REQUEST

Proposed Zoning: IMU(CD) (Innovation Mixed-Use, conditional)

Approximately 7.4 acres along the southwest side of Brookshire Boulevard and the southeast side of Fred D Alexander Boulevard.

PLANNING STAFF REVIEW

SHEET NO.  
**RZ-100**

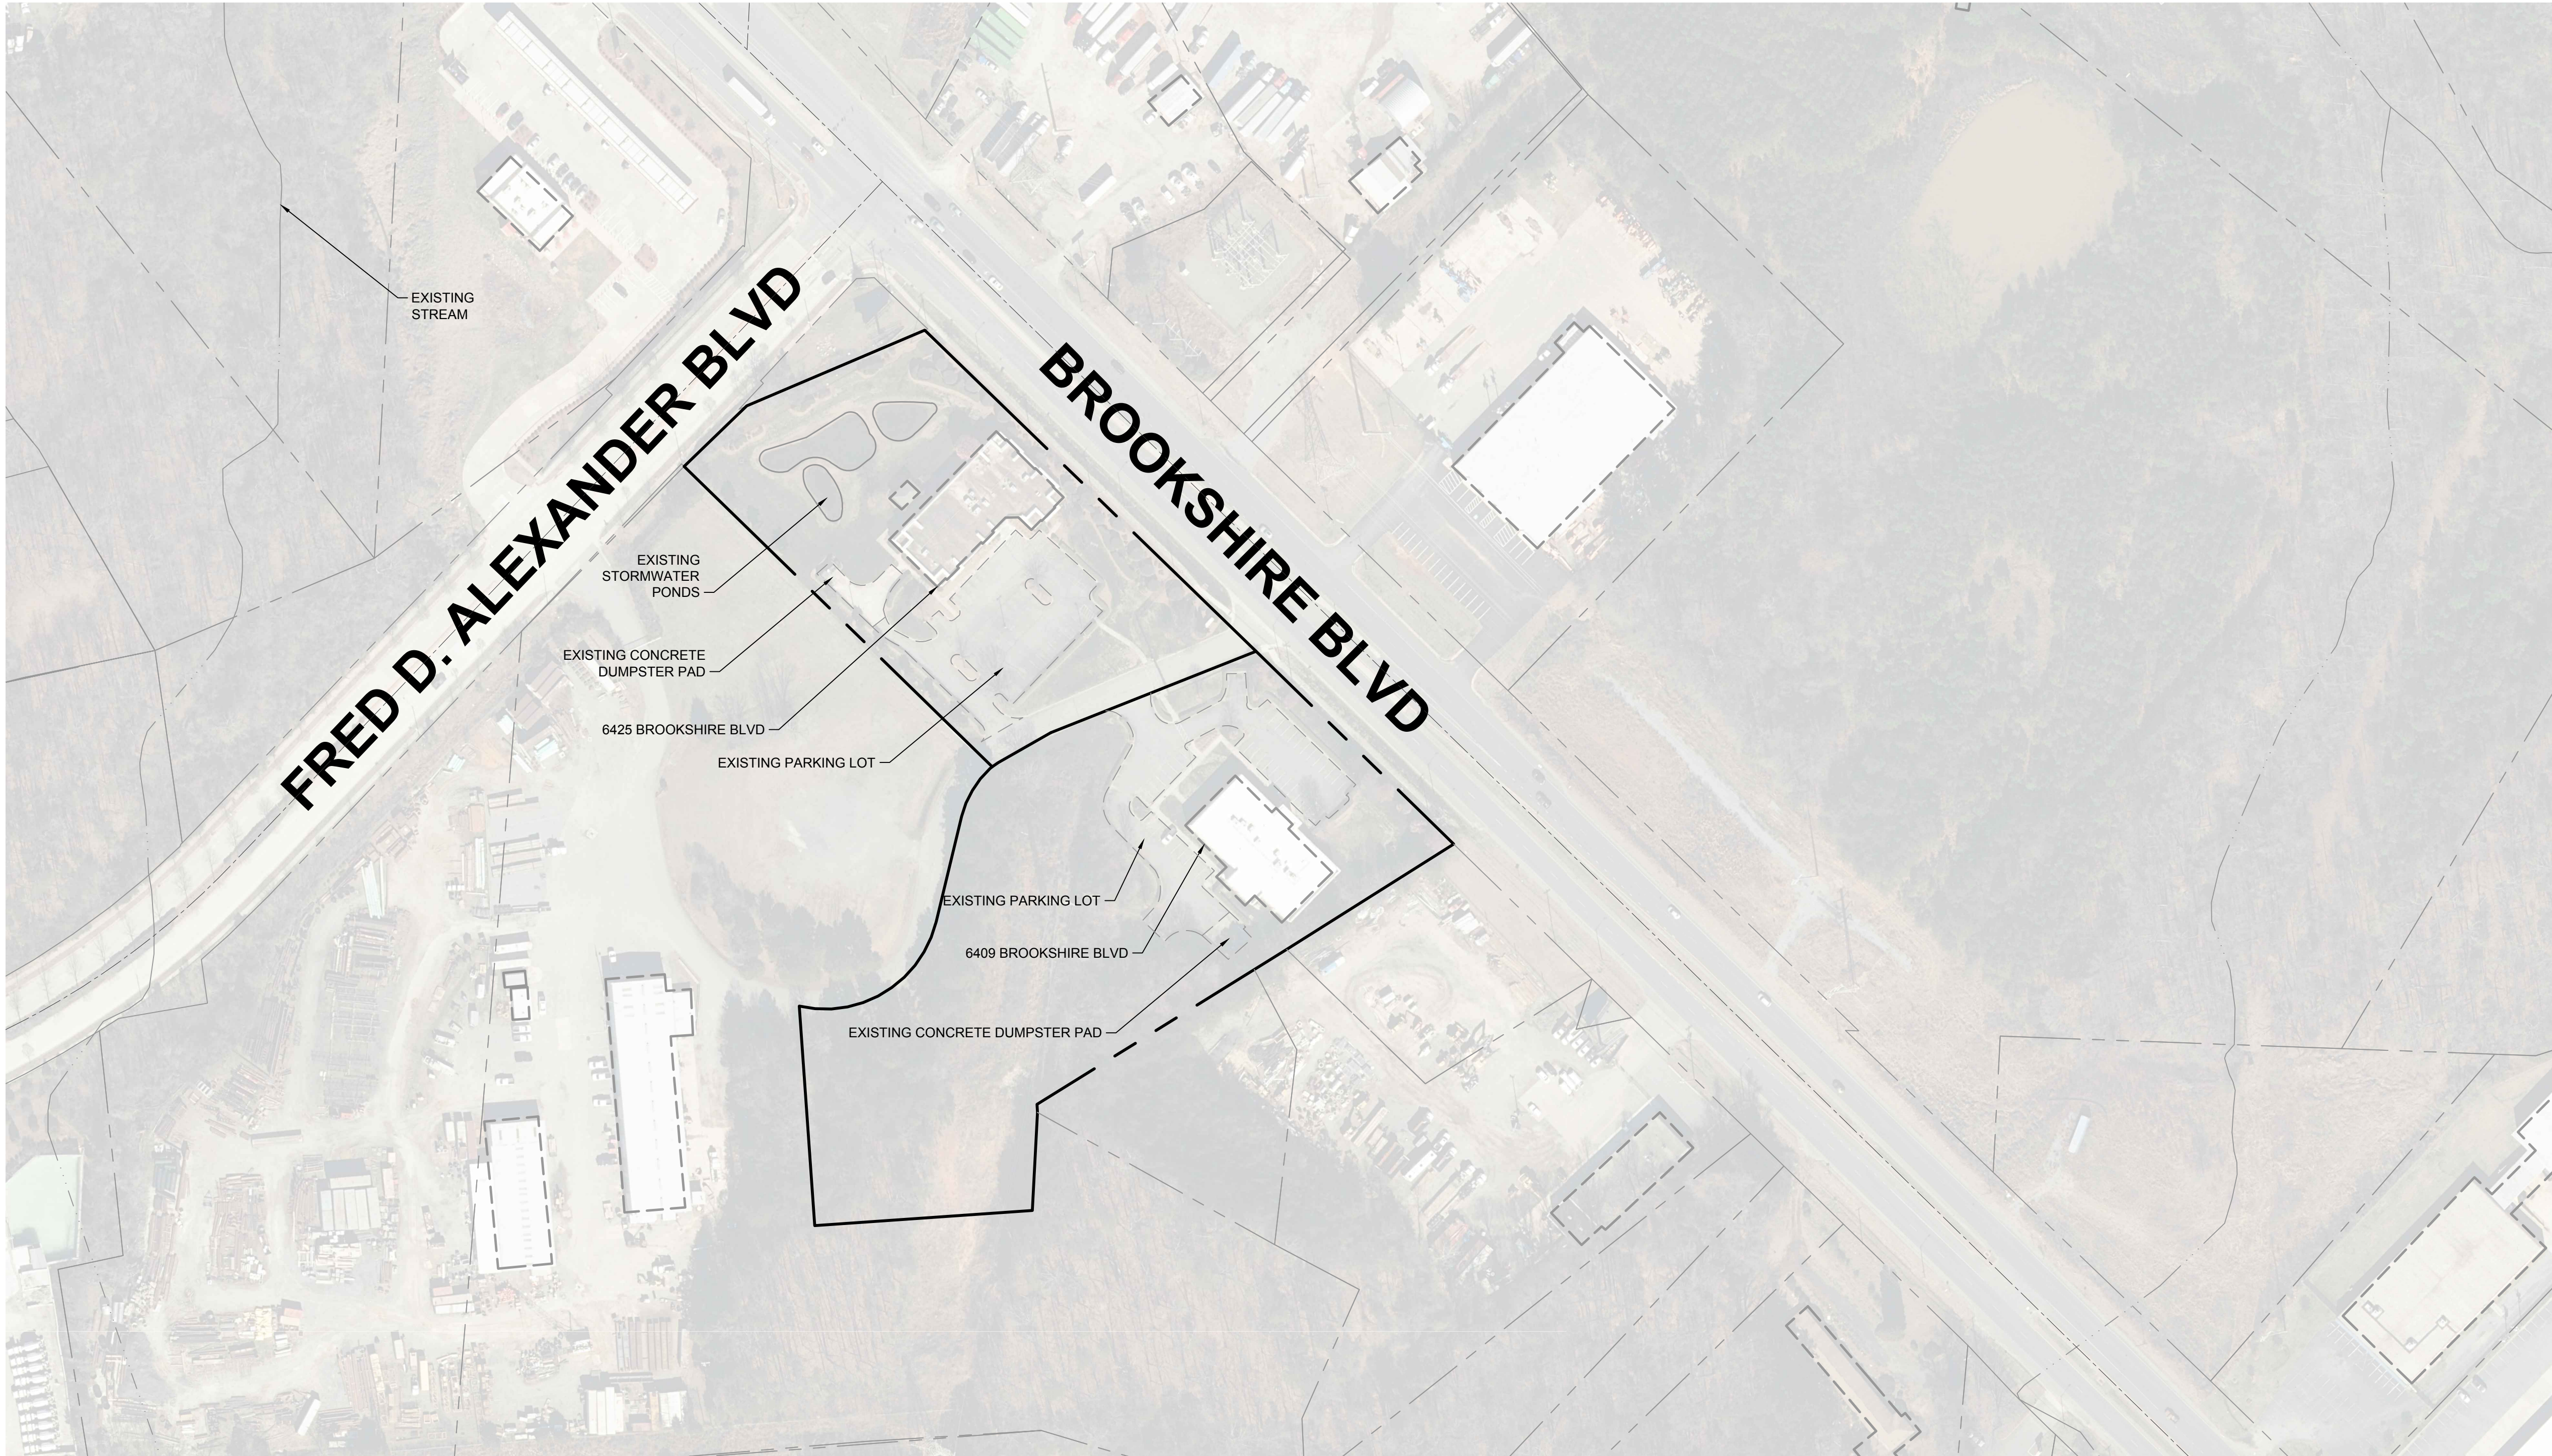
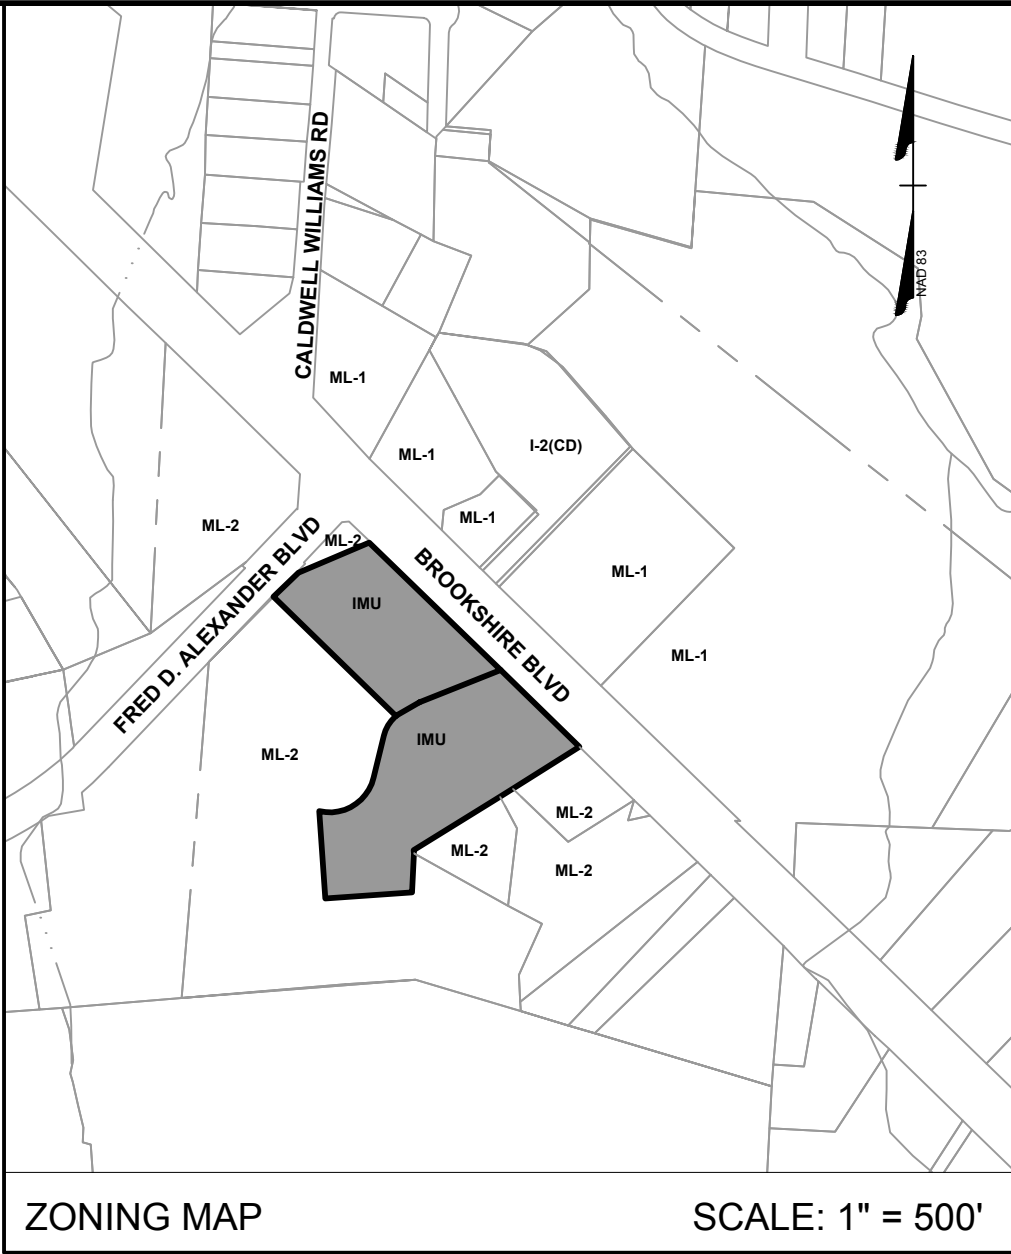
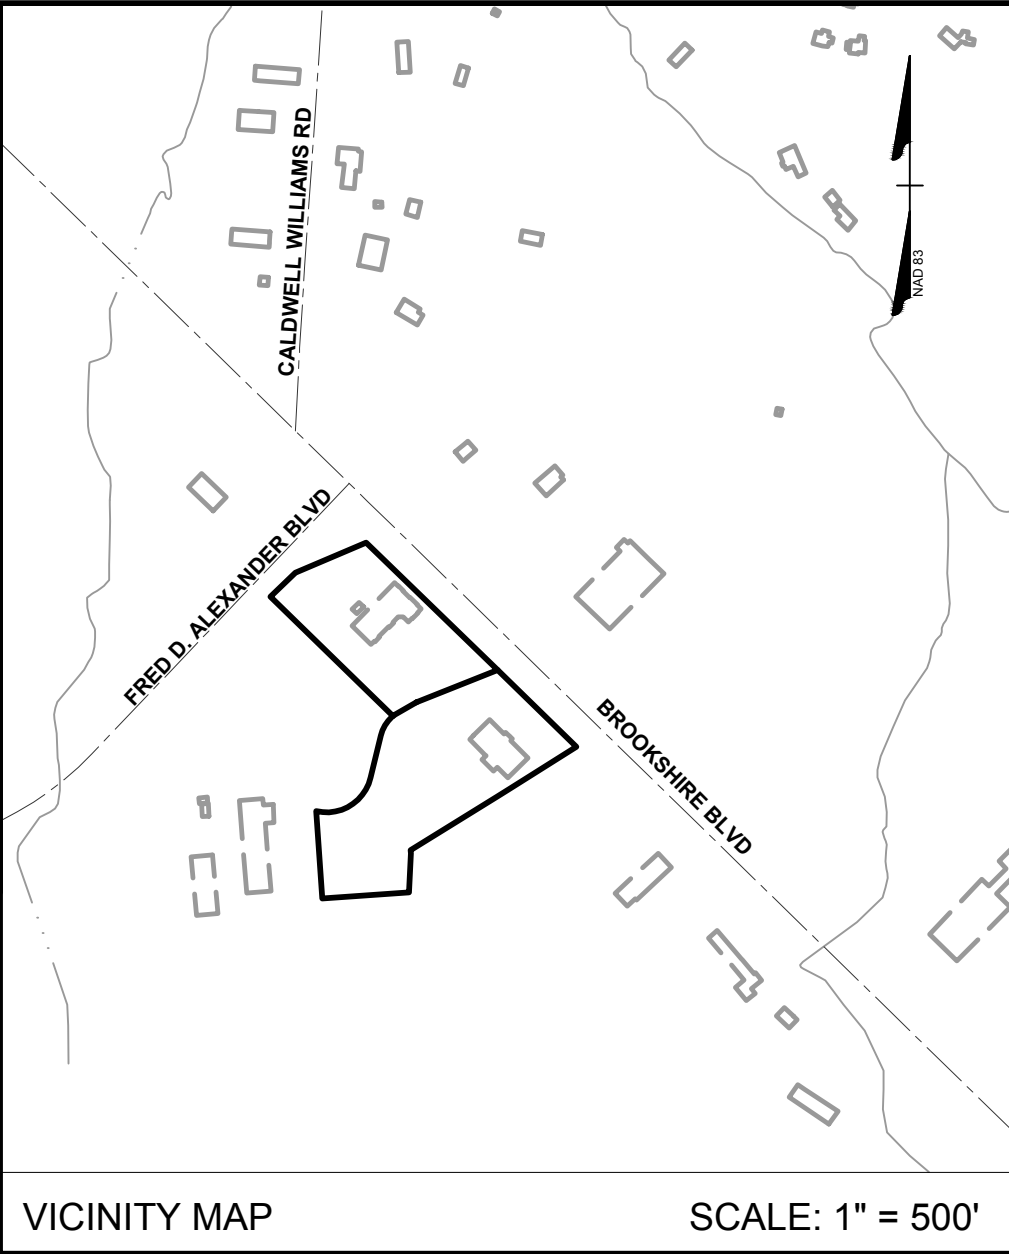
1. ~~CDOT: **Fred D. Alexander Boulevard:** Location of future curb and gutter is to be 41' from centerline. 4' Boulevard Buffered/Separated Bike Lanes per Charlotte Streets Map. Label and dimension the curb and gutter from the centerline for each road on the site plan. **Addressed**~~
2. ~~CDOT: Brookshire Boulevard: Location of future curb and gutter is to be 44' from centerline. 6' Boulevard, Shared Use Path per Charlotte Streets Map. Label and dimension the curb and gutter from the centerline for each road on the site plan. **Addressed**~~
3. ~~CDOT: Comprehensive Transportation Review (CTR): Square footage needed to determine potential CTR and streetscape requirements. Additional comments or requirements may arise once unit count is provided. **Addressed**~~

4. ~~Urban Forestry: A tree survey shall be required for all conditional zoning map amendments. **Addressed**~~
Urban Forestry: Update conditional note under General provision 8.B to reference Article 20 of the UDO. **Addressed**

5. ~~Entitlement Services: Update conditional note 2 under general provisions to reference Article 37 of the UDO. **Addressed**~~
6. ~~Entitlement Services: Update required setback on Brookshire Blvd to 24 feet. **Addressed**~~
7. ~~Entitlement Services: Add proposed square footage to parcel 03505513. Show area of expansion graphically for parcel 03505512. **Addressed**~~

8. ~~Urban Forestry: Show heritage trees and trees that are within the right of way. **Addressed**~~

9. ~~CDOT: Current site plan shows 4' planting strip on Brookshire Boulevard this needs to be designed and labeled as 8'. **Addressed**~~
